**Rezoning Transportation Analysis**  
**Petition Number: Insert Zoning Petition #2021-015**  
*General Location Identifier: 11504601, 11504613*

**Revision Log:**

Date	Description
02-25-2021	First Review (KP)
03-25-2021	Second Review (KP)

**HOLABIRD LANE & WEST BOULEVARD  
CHARLOTTE, NC  
REZONING PLAN**

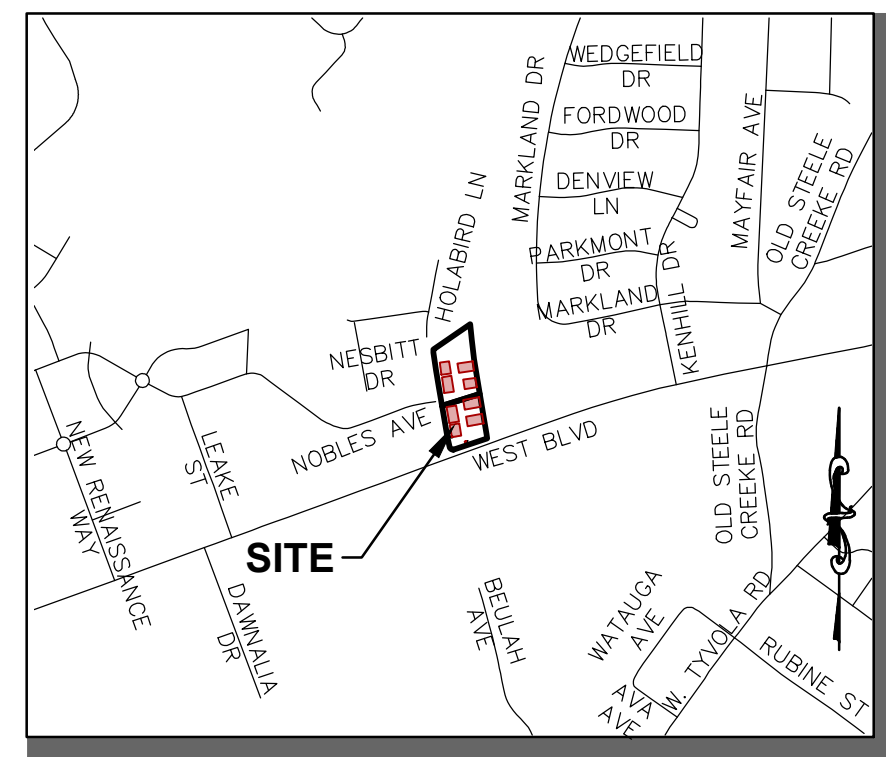
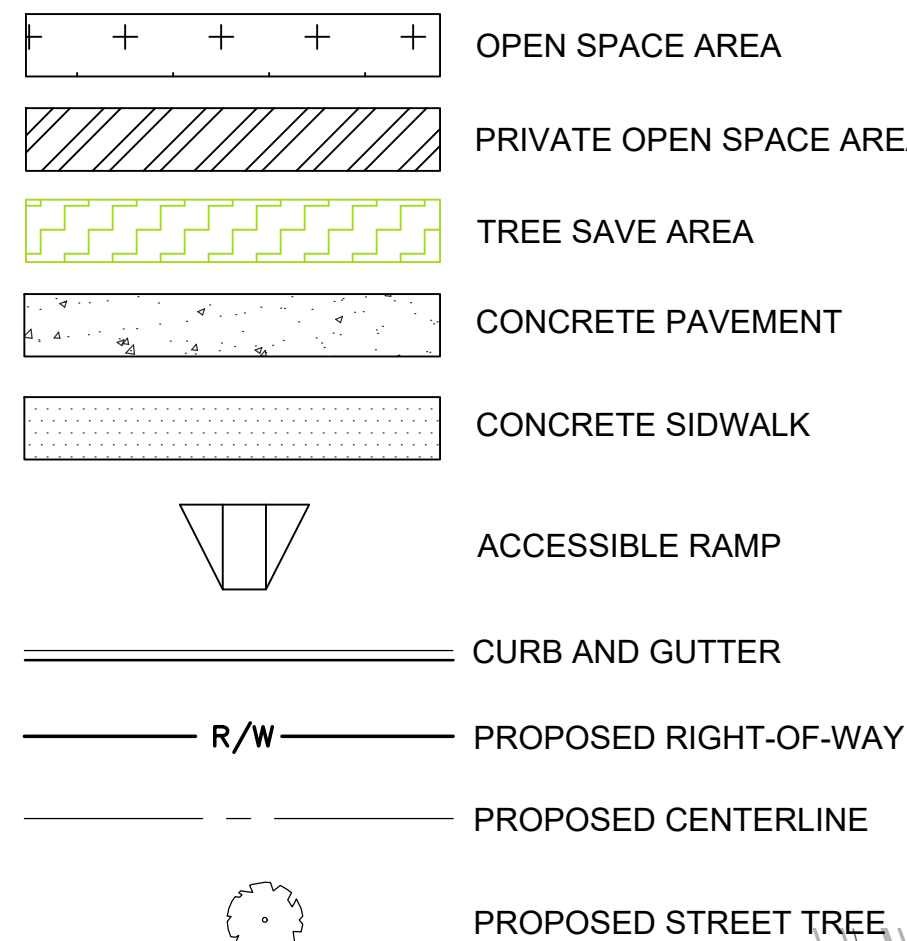
- a. ~~West Boulevard:~~ The future curb line for West Boulevard will be 32.5 feet from the existing road centerline to back-of-curb.
- b. **Holabird Lane:** The petitioner will construct the curb 17.5-feet from the existing road centerline to the back-of-curb. **Update to Comment as a result of 03/16/2021 Site Plan: Label and dimension the curb line from the centerline of Holabird.**

Revise the site plan by labeling and dimensioning the back-of-curb from the centerline of each road.

- 5. Revise the site plan and conditional notes by constructing an 8-foot buffered bike lane, 3-foot buffer with 5-foot travel lane, along the site's West Boulevard frontage. **Update to Comment as a result of 03/16/2021 Site Plan: Show the bike lane on the site plan and label and dimension from the existing centerline of West Blvd.**

Label and dimension from the centerline of West Boulevard.

- 8. Revise the site plan and conditional notes by committing to the replacement of the ADA compliant curb ramps at the intersection of West Boulevard and Holabird Lane. **Update to Comment as a result of 03/16/2021 Site Plan: Revise the site plan to replace/construct both curb ramps on each side of Holabird.**
